Fire Marshal Division

Re: Erwin Denim Days
100 North 13th St.
Erwin, NC 28339

Application Number – FMFW1909-0005

- 1) Chamber Tent
- 2) Zaxby's Tent
- 3) Papa John's Tent
- 4) Hotdog cart
- 5) DD+J concession
- 6) Porta-John
- 7) Handwash Station

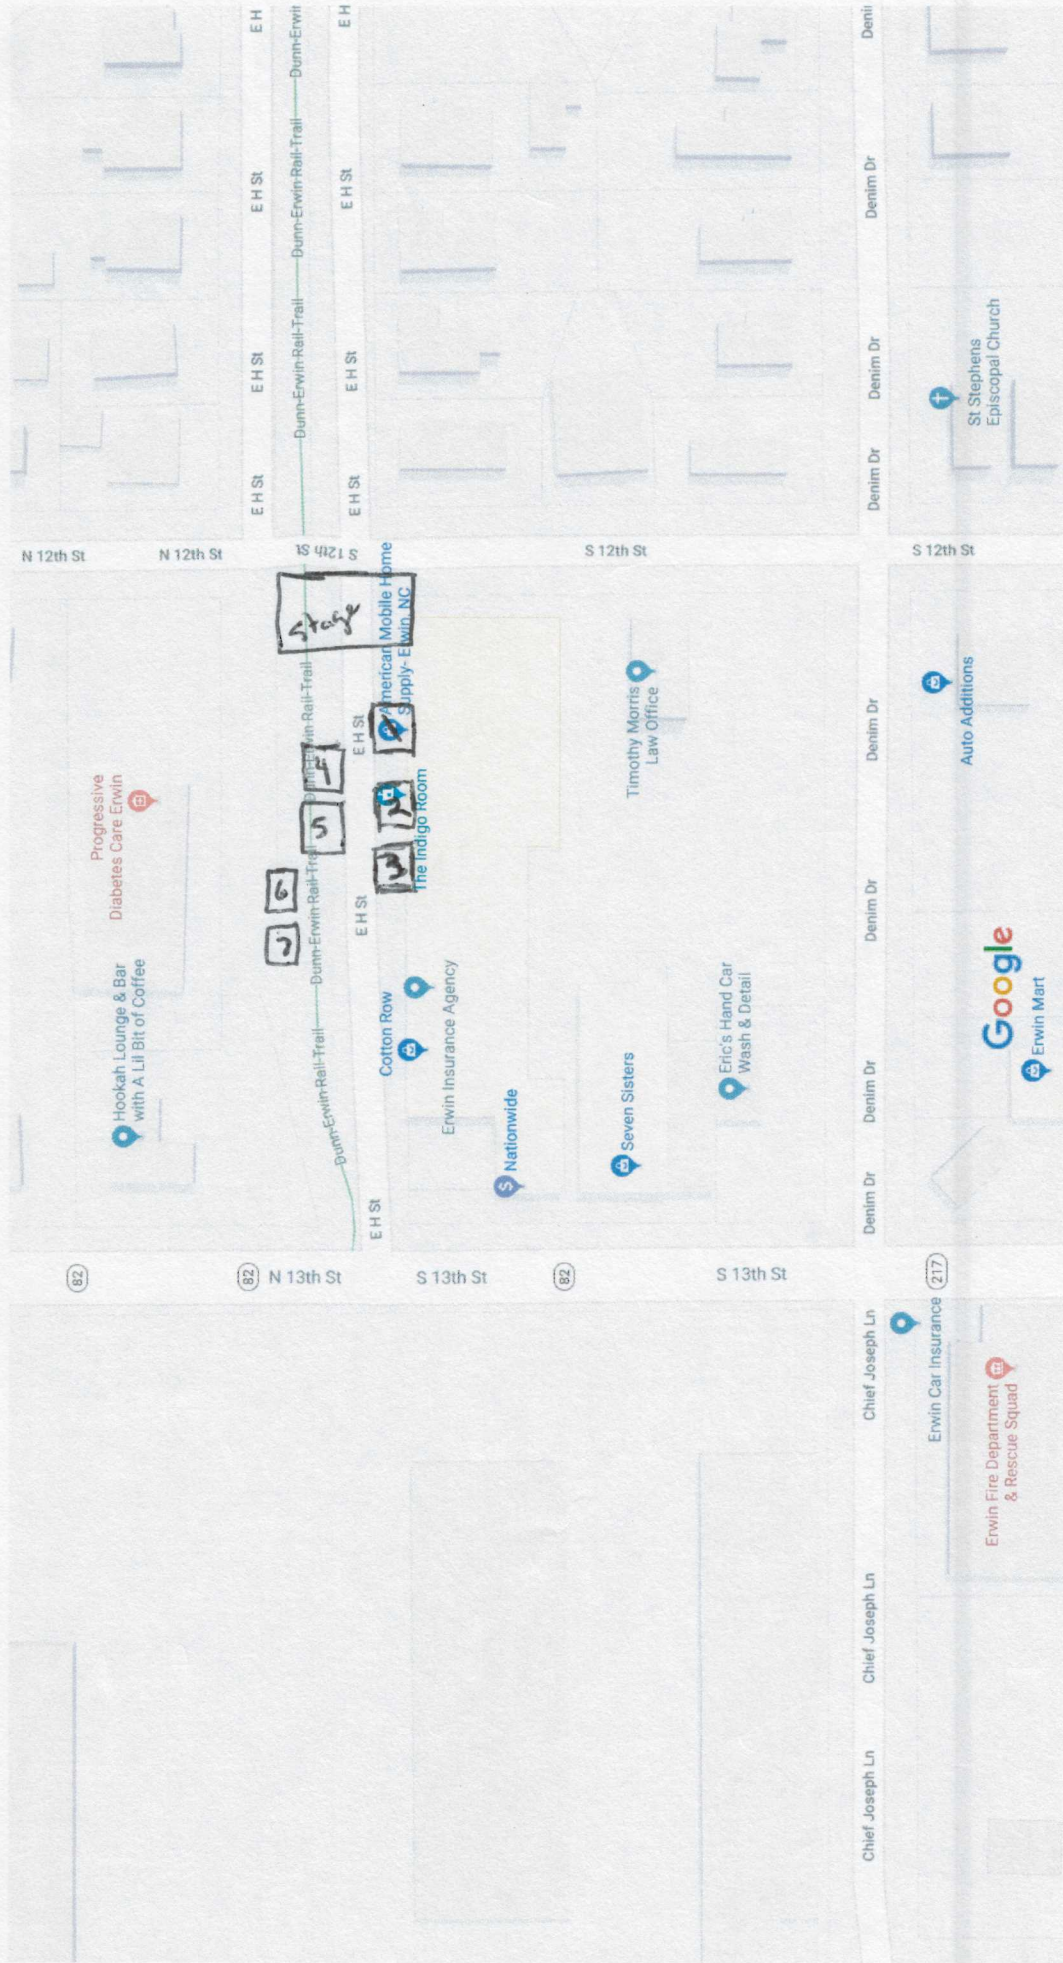
- Outdoor cooking that produces sparks or grease-laden vapors shall not be performed within 20 feet (6096 mm) from a tent, air-supported, air-inflated or tensioned membrane structure, temporary membrane structure or canopy

- Cooking is permitted under flame resistant tents meeting NFPA 701 Flame Propagation Standard with a minimum separation of 20' from lot lines, buildings, parked vehicle, other tents and membrane structures.
-

- **2411.5 Cooking tents.**
 - Tents where cooking is performed shall be separated from other tents, air-supported, air-inflated or tensioned membrane structures, temporary membrane structures or canopies by a minimum of 20 feet (6096 mm).
-

- **2415 Generators**
 - Generators and other internal combustion power sources shall be separated from tents, air-supported, air-inflated or tensioned membrane structures, temporary membrane structures or canopies by a minimum of 20 feet (6096 mm) and shall be isolated from contact with the public by fencing, enclosure or other approved means.
-
